16th August 2022
Rev 2 – 17.8.22

RE: FORMER BARTONS INFANT SCHOOL, BERSTED
Council Ref: BE/40/22/PL

Technical Note in response to LLFA comments

Extract of utilities survey showing existing school outfall

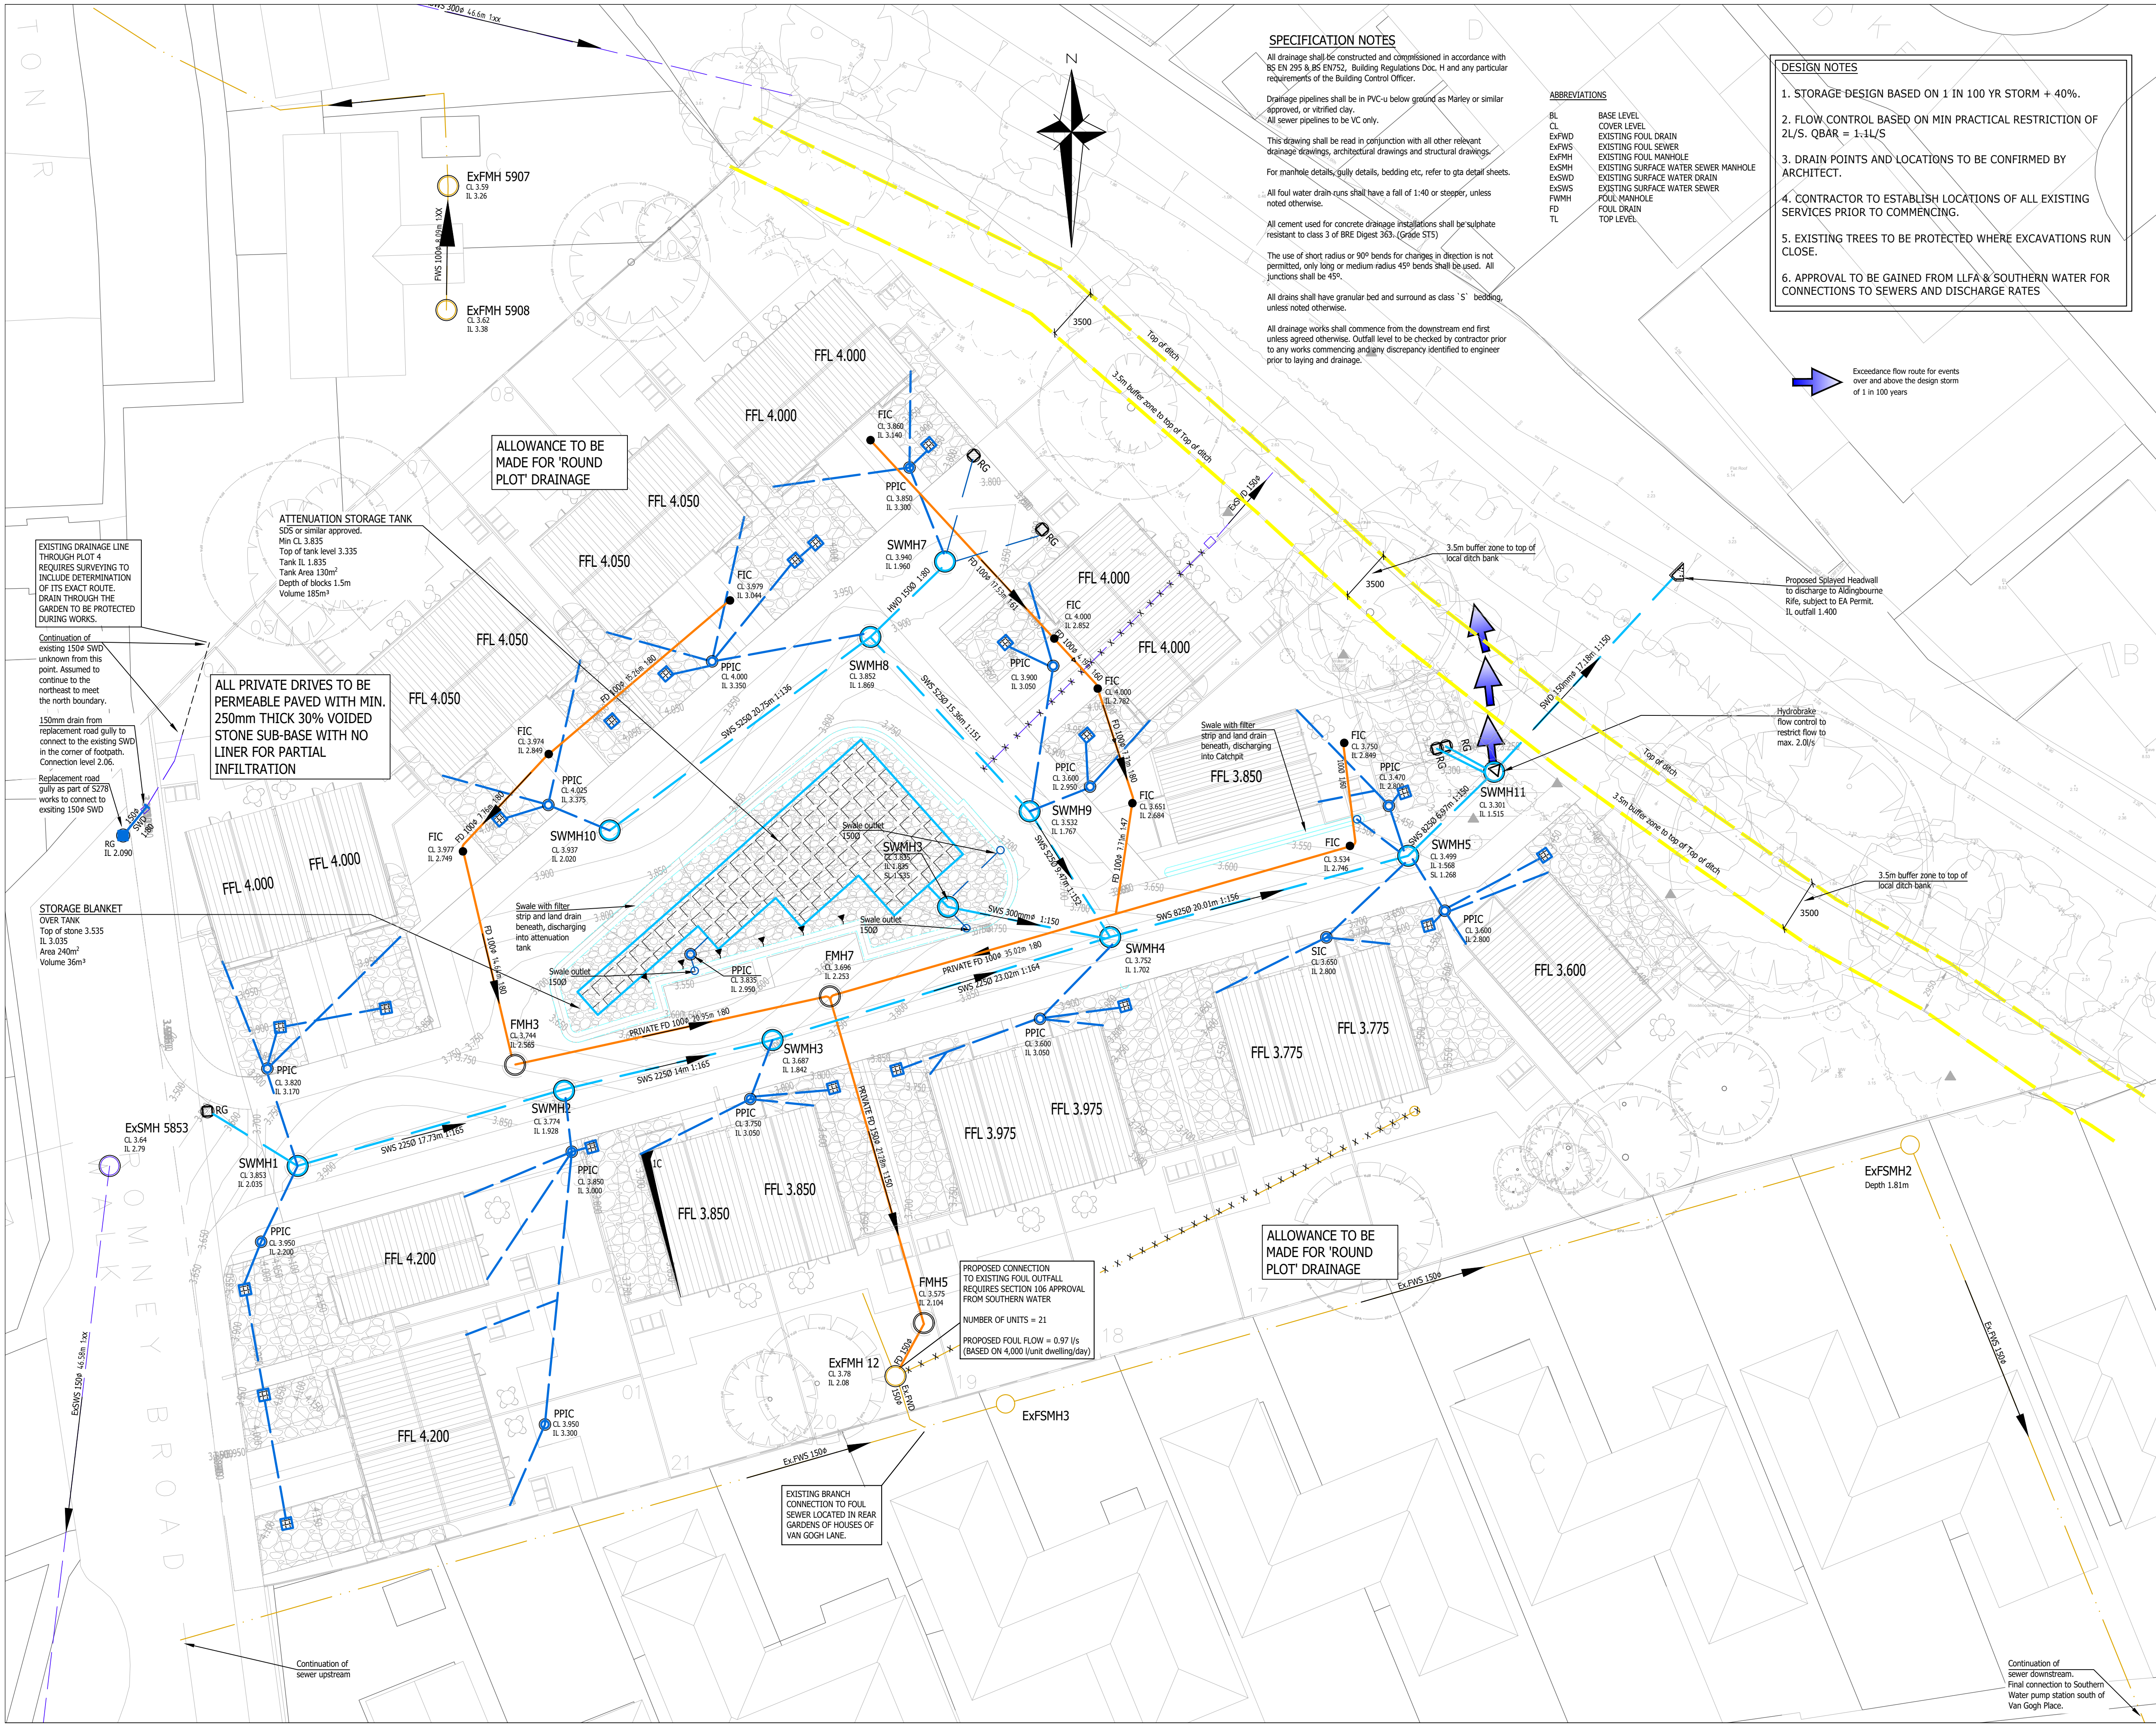
- 5) We are unsure how the ditch / small watercourse adjacent to the site connects to the nearby main river and we have concerns regarding how onward connection from the development site to this watercourse, or the main river will be achieved.

- The drainage layout shows the proposed onward connection to the main river crossing the smaller ditch channel. There is likely to be works required to facilitate the connection as shown, or to ensure the ditch / small channel is fit for purpose and has onward connectivity to the main river if a connection to this feature is proposed at the detailed design stage.

- We require additional details of the proposed connection, including whether an existing connection between the main river and smaller channel is present.

- We require details of how any pipework can be accommodated / will pass through the area where the existing ditch / channel is. This pipework should remain above the water level within the main river.

We have searched the area and we cannot find connectivity between the small watercourse and main river due to dense undergrowth.

The proposed connection is mimicking the existing school outfall location which is shown on the survey plan appended, extract below:

The only reason this existing outfall was not used was that it is not in a convenient location for future maintenance, as the manhole falls in the garden of plot 13.

The level of the existing outfall is likely to be somewhere in the region of 1.4m AOD (as upstream chamber is 1.54m) which is what we are proposing, so the new outfall will have no more impact than the existing, especially taking into account this used to have no flow restriction from the school site.

The main rife ditch bed level has been surveyed at approximately 1.020m AOD in the vicinity of the connection with no water level in the rife present. So the connection is 380mm above bed level which we feel is more than sufficient.
